Application for a non-material amendment following a grant of planning permission.

<input type="text" value="Proposed single storey extension and dormer to rear"/>	
Reference number:	<input type="text" value="3/2020/1055"/>
Date of decision	<input type="text" value="05/02/2021"/>

SIDE ELEVATION 1:50

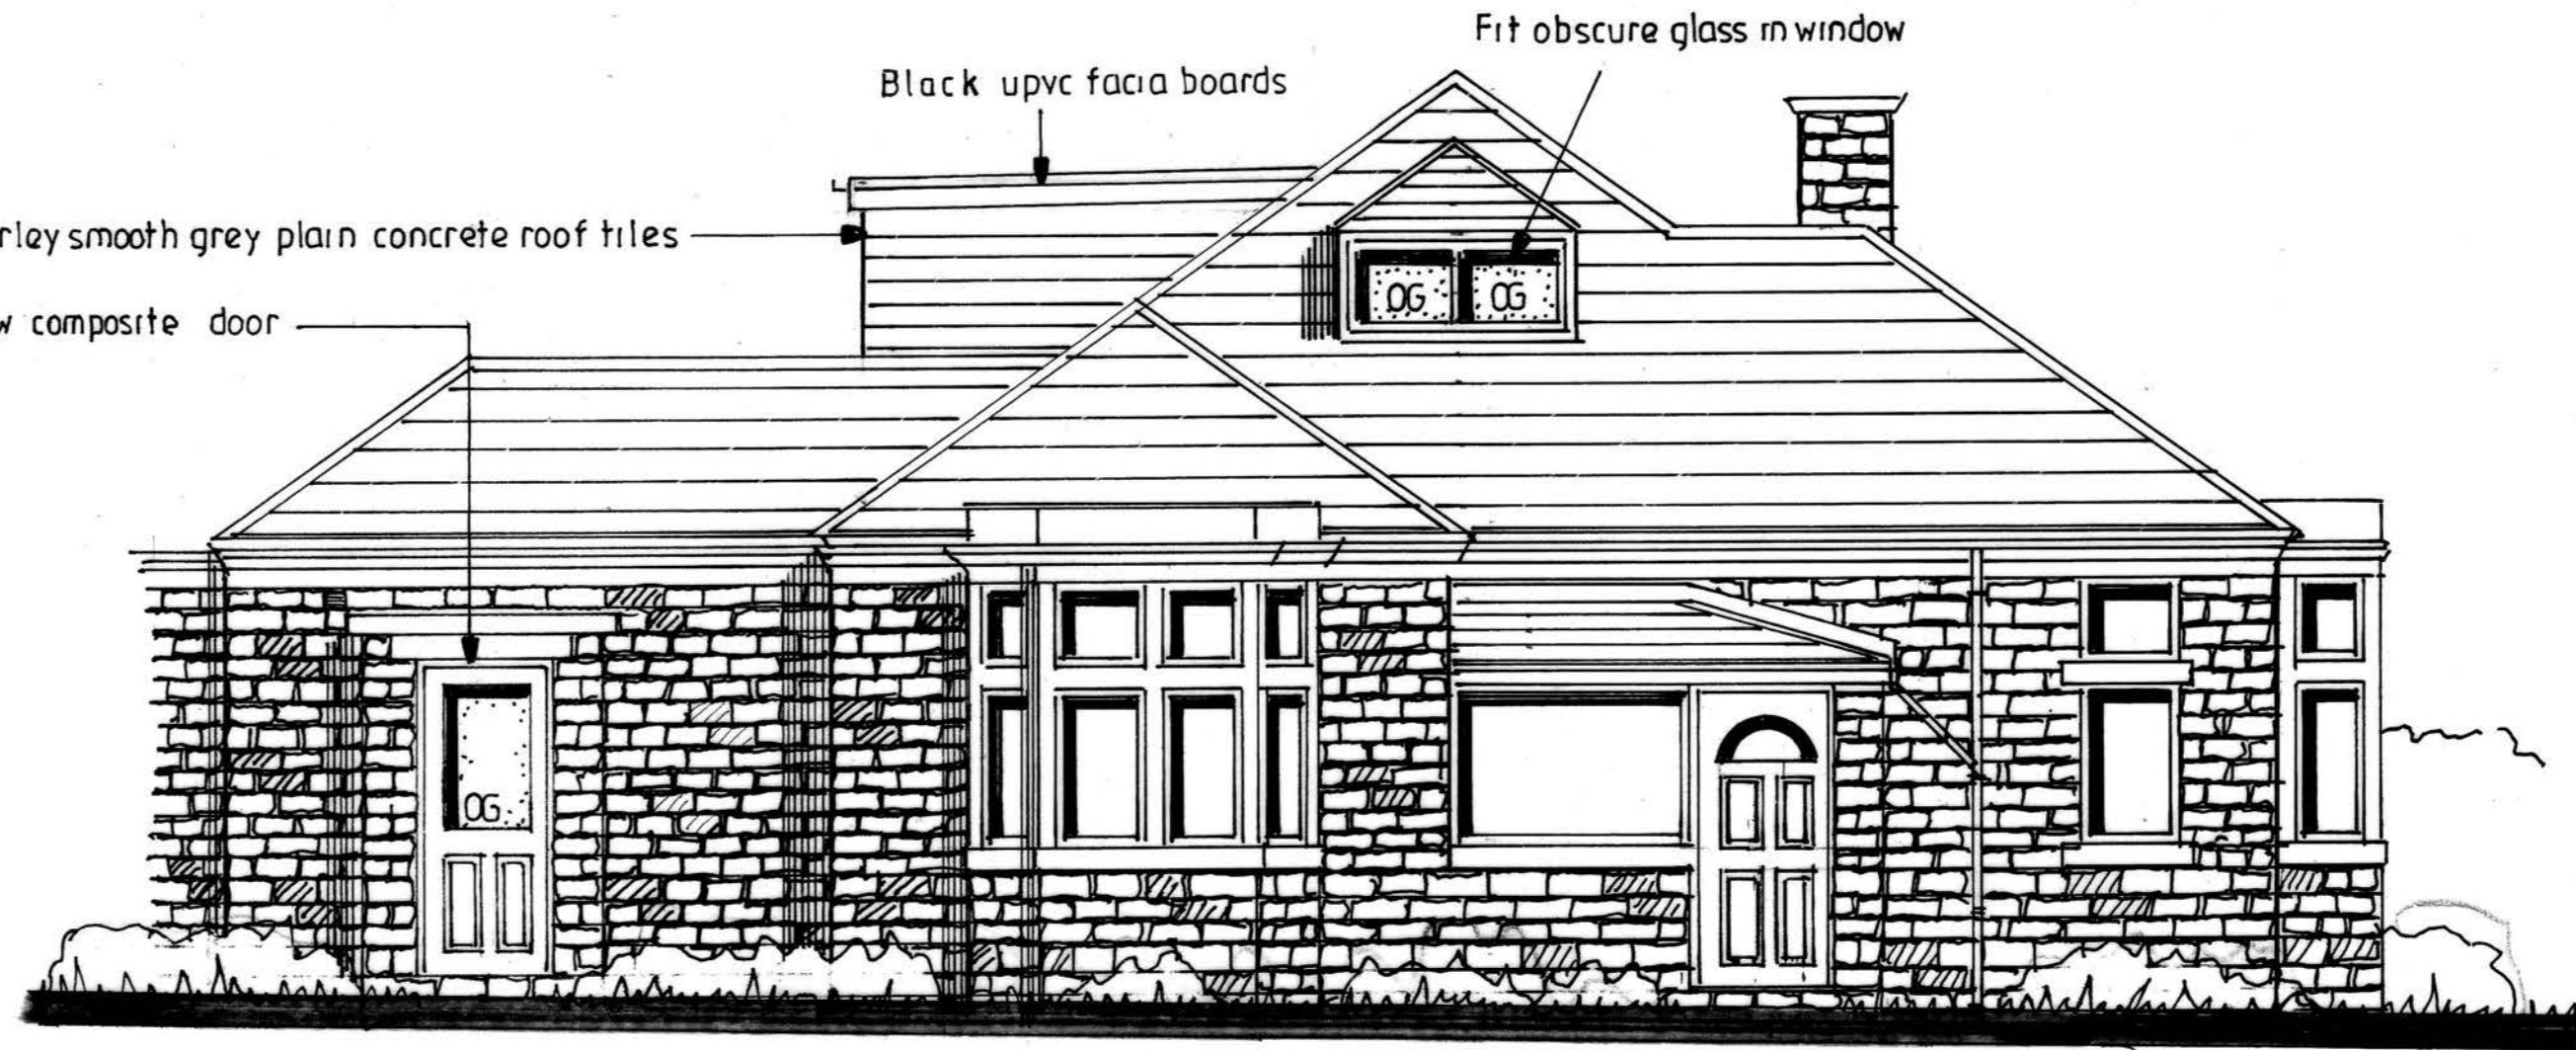
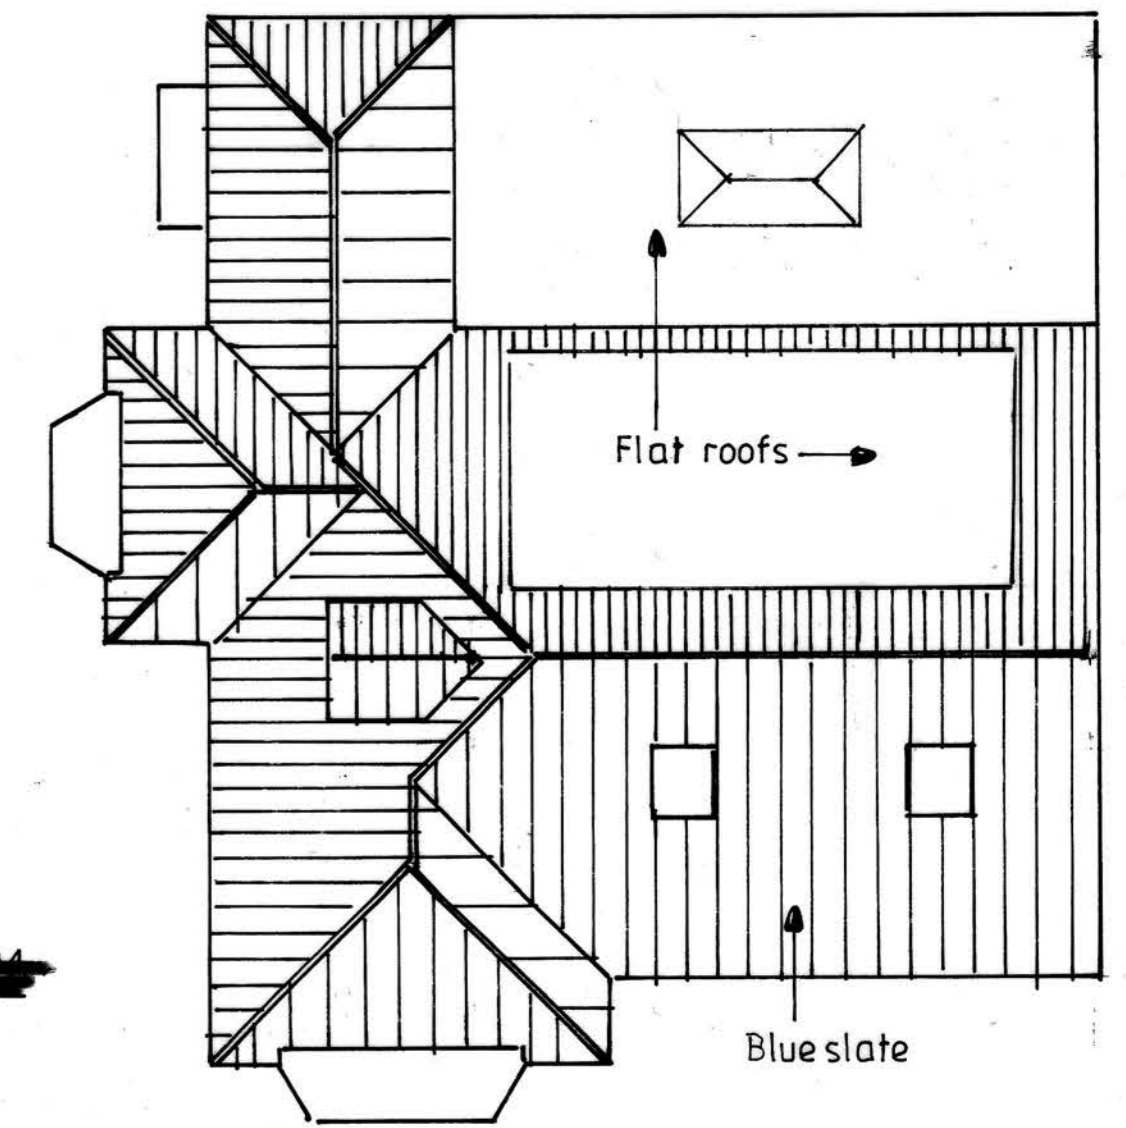
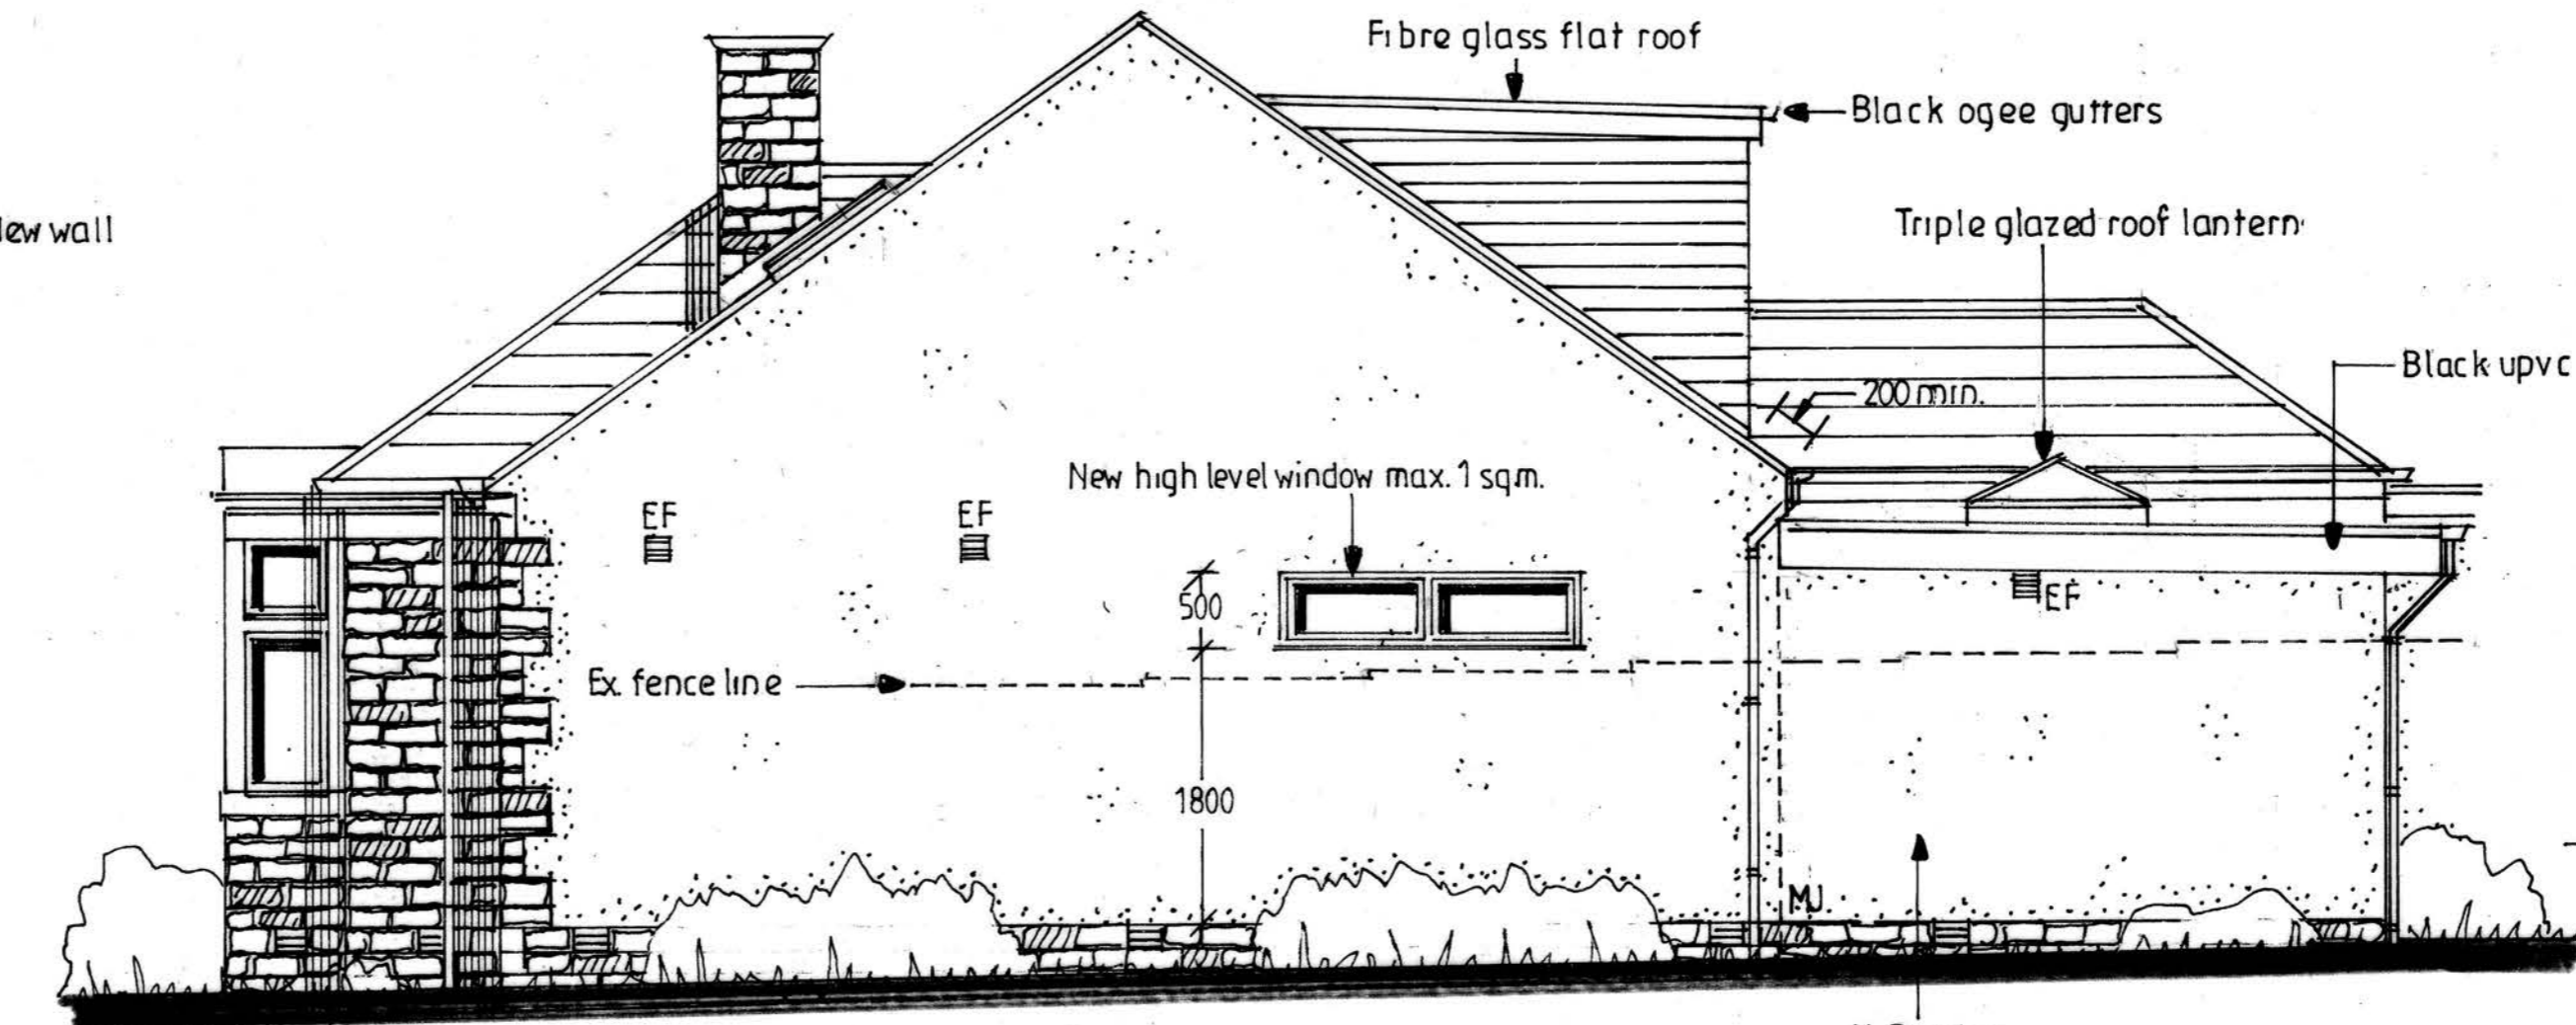
Fascia boards on dormer and rear extension changed from white to black.  
White upvc windows and doors on rear elevation changed to black aluminium.  
Utility door changed from white upvc to a colour composite door.  
Small window in utility room deleted.  
High level window inserted in the family room on the side elevation.  
Orientation of roof lantern in the kitchen/ dining room amended and size increased to 2.4m x 1.2m

The original white upvc windows and doors that were being matched were found to be in poor condition and in need of replacement so the owner would like to change them to black; fascia boards are being altered to match.  
The high level window in the family room is to provide additional natural light and ventilation.  
Small window in the utility room is being deleted to allow for additional high level storage units.  
The kitchen designer has suggested turning the lantern window and increasing it slightly in size to provide more light.
